**From:** Bernadette Owens  
**Sent:** 21 December 2020 12:01  
**To:** DC Support  
**Subject:** 20/02779/REM

**From:** Charlotte Watkins <Charlotte.Watkins@Cherwell-DC.gov.uk>  
**Sent:** 18 December 2020 23:54  
**To:** Bernadette Owens <Bernadette.Owens@Cherwell-DC.gov.uk>  
**Subject:** 20/02779/REM

**Ecology Officer**

Document title
RESERVED MATTERS
PHASE 1 LANDSCAPE SECTIONS

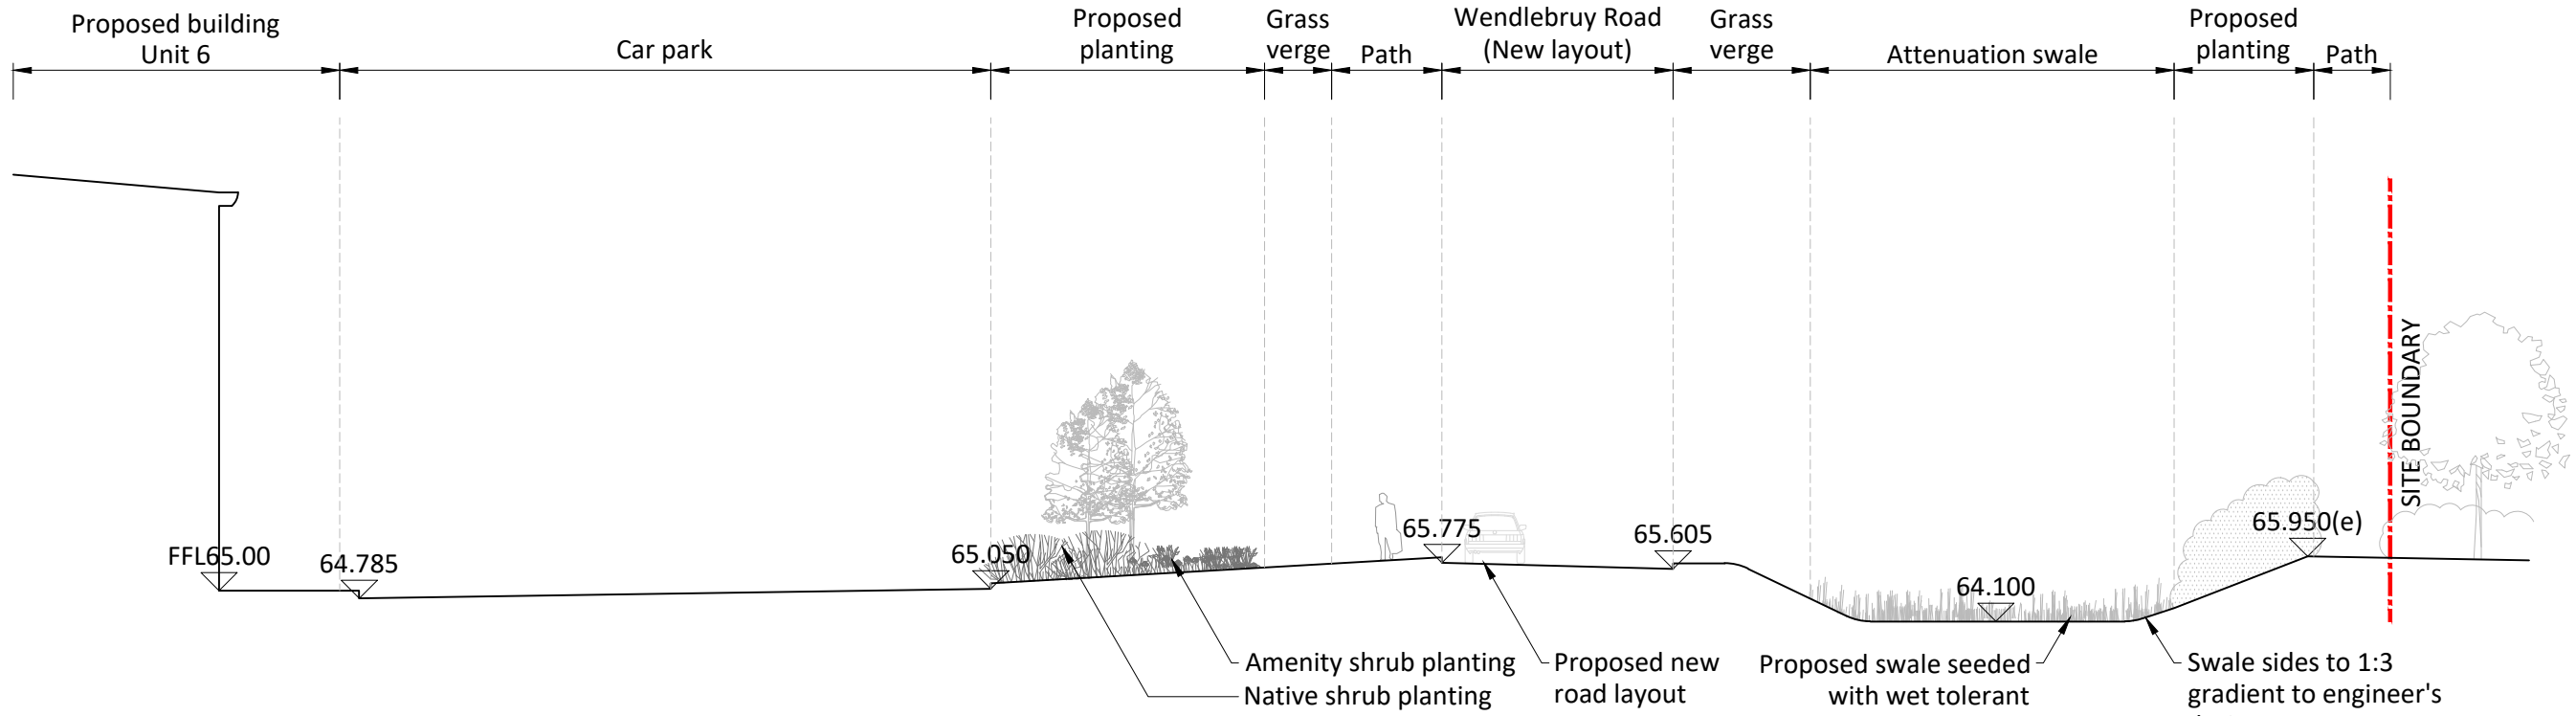
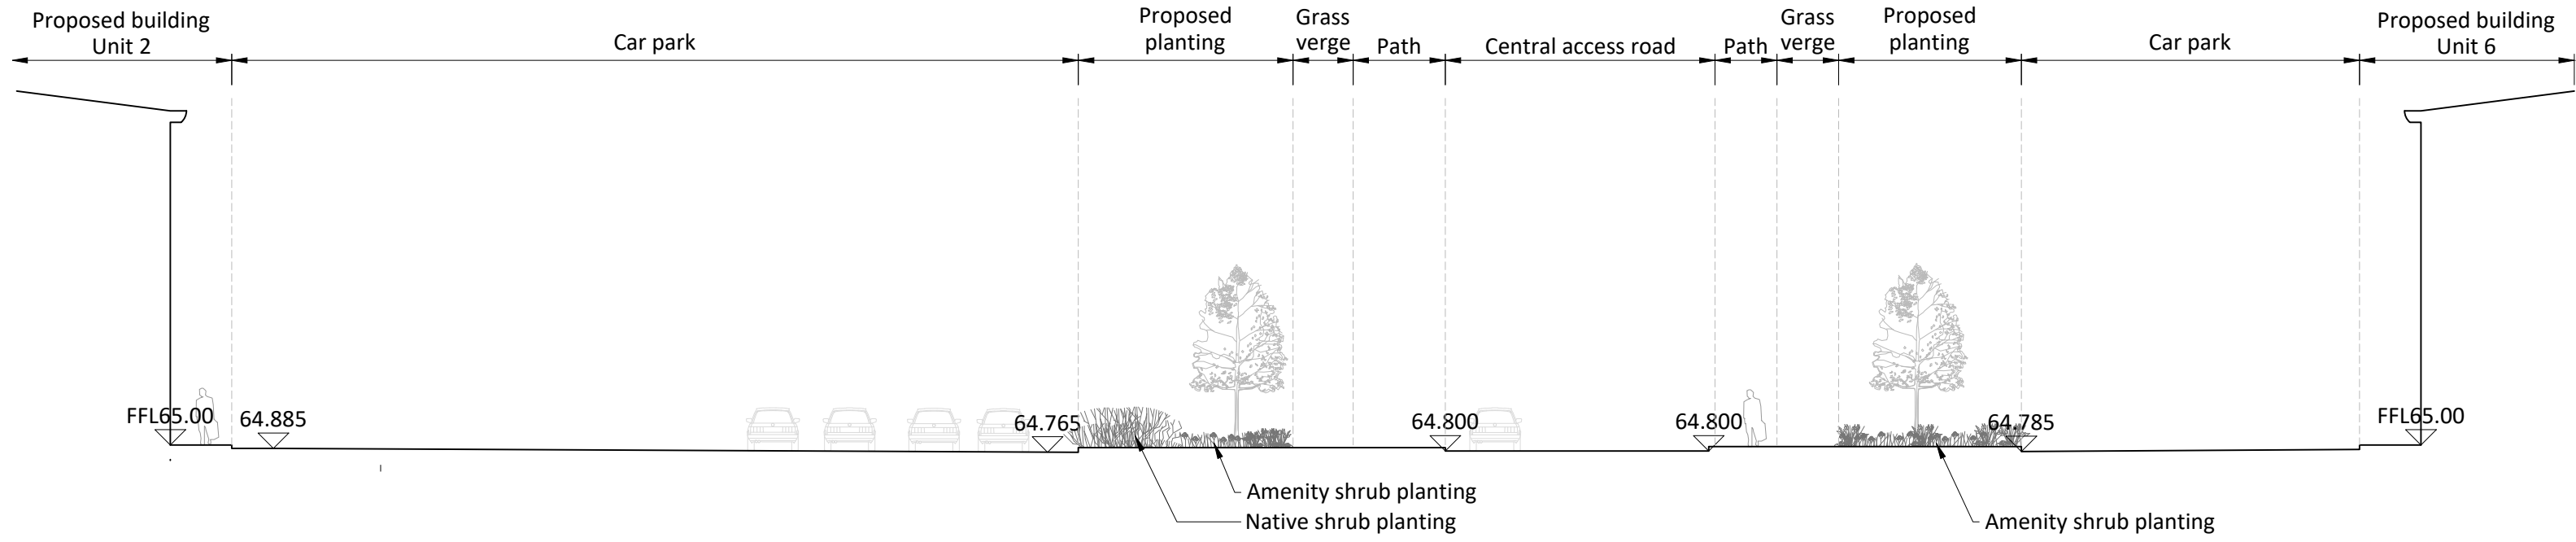
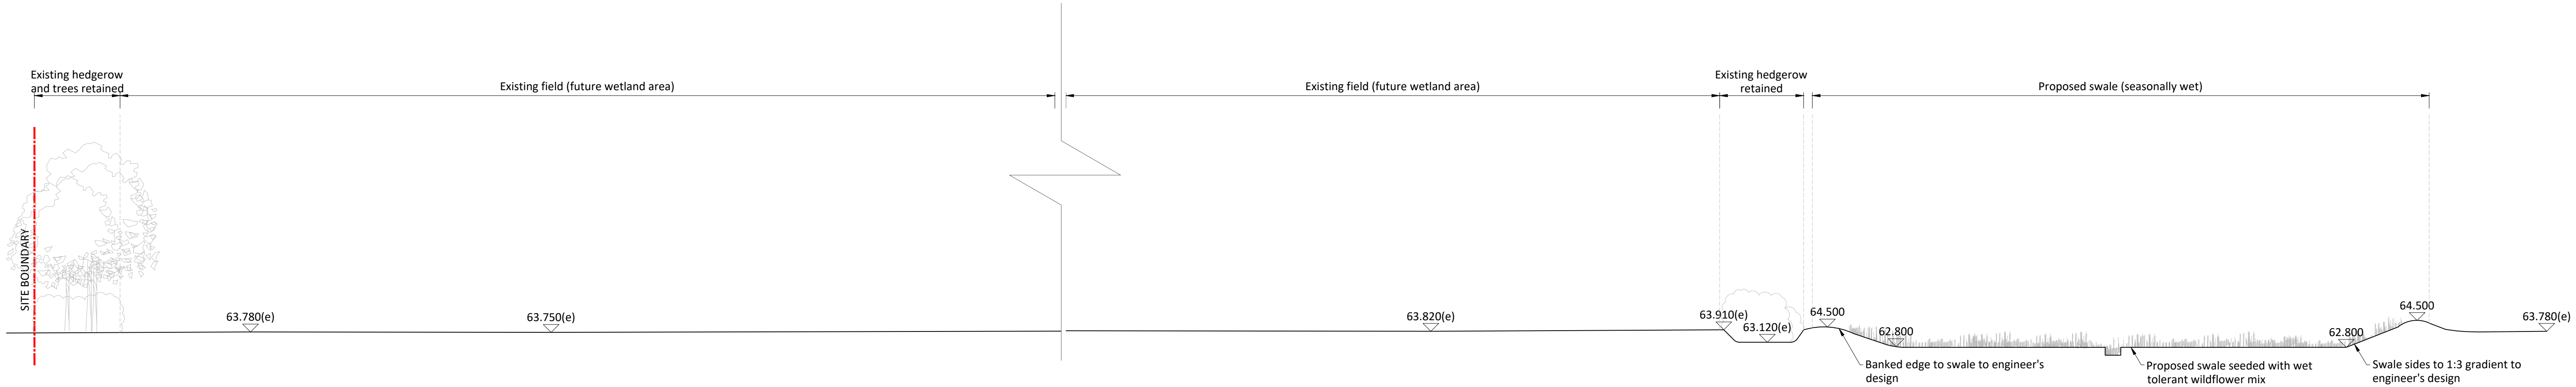
In general the landscaping locations broadly follow those set out in the outline application and I have no particular issues with them. My main comment would be that it would be preferable if they would sow more interesting grassland rather than having amenity grass only, particularly in areas where there is unlikely to be a need for amenity use such as the roundabout and areas of grass at the entrance. A meadow grass seed mix managed for wildlife (i.e. left long in parts) would have much greater benefits for invertebrates as well as other species. These aspects are difficult to assess without an overall LEMP yet in place giving reasoning and objectives for planting choices in each location.
